From: Claire Forrest
Sent: 26 June 2008 11:06
To: Planning.Responses
Subject: FW: Planning Application BR/110/08/

From: Ian.Gledhill@westsussex.gov.uk [mailto:Ian.Gledhill@westsussex.gov.uk]
Sent: 26 June 2008 10:58
To: Claire Forrest
Subject: Re: Planning Application BR/110/08/

Given the timescales, I hope you don't mind the emailed response. I've reviewed the revised plans and would offer the following comments.

Ground Floor 2 No Apartments

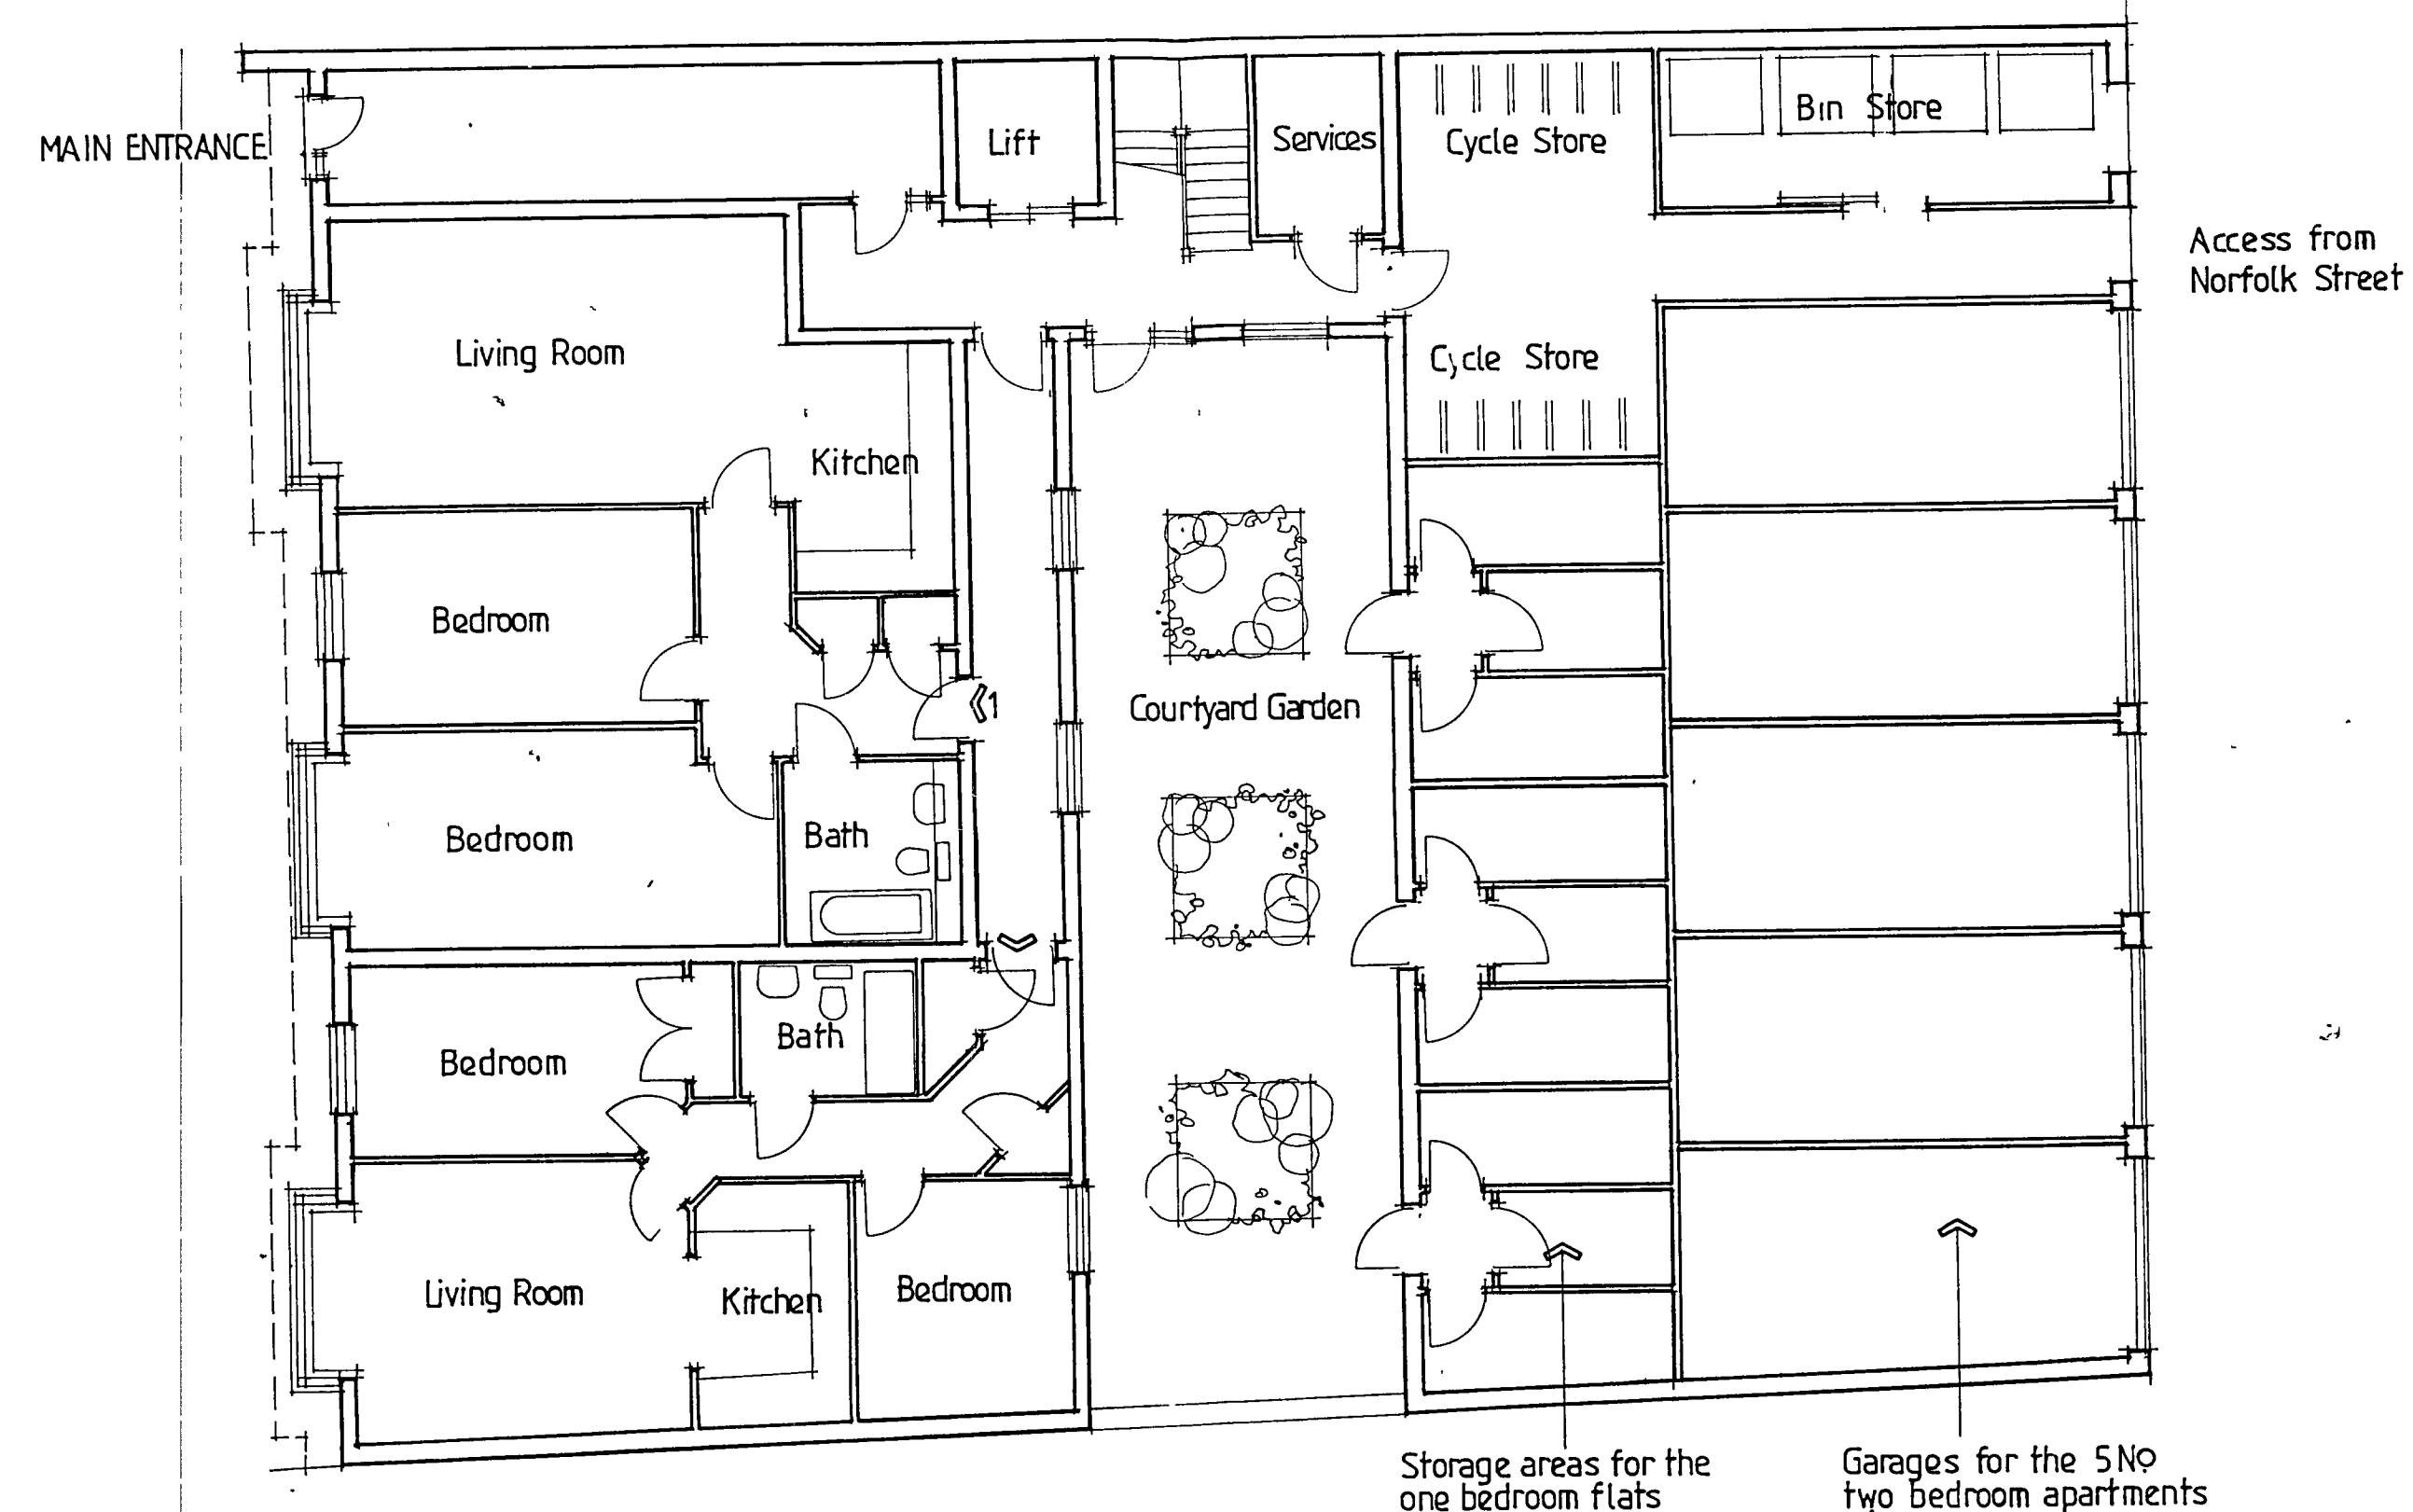
Five car parking spaces are now to be provided for the benefit of the two bedroom units. These are to have direct vehicular access from Norfolk Road. No significant concerns would be raised with the provision of access. The proposed level of car parking has been decreased from the initial consultation and no concerns would be raised through the provision of five car parking spaces as this is still within the WSCC maximum parking standard. The site is located within Bognor Town centre, thus enabling good access to a range of services and frequent passenger transport, which should encourage an increase in walking, cycling and the use of passenger transport, as well as minimising the number and impact of motorised journeys. It is noted that improved access is also now provided to the cycle store, which isn't hindered by the proposed car parking.

No objection would be raised to the proposals.
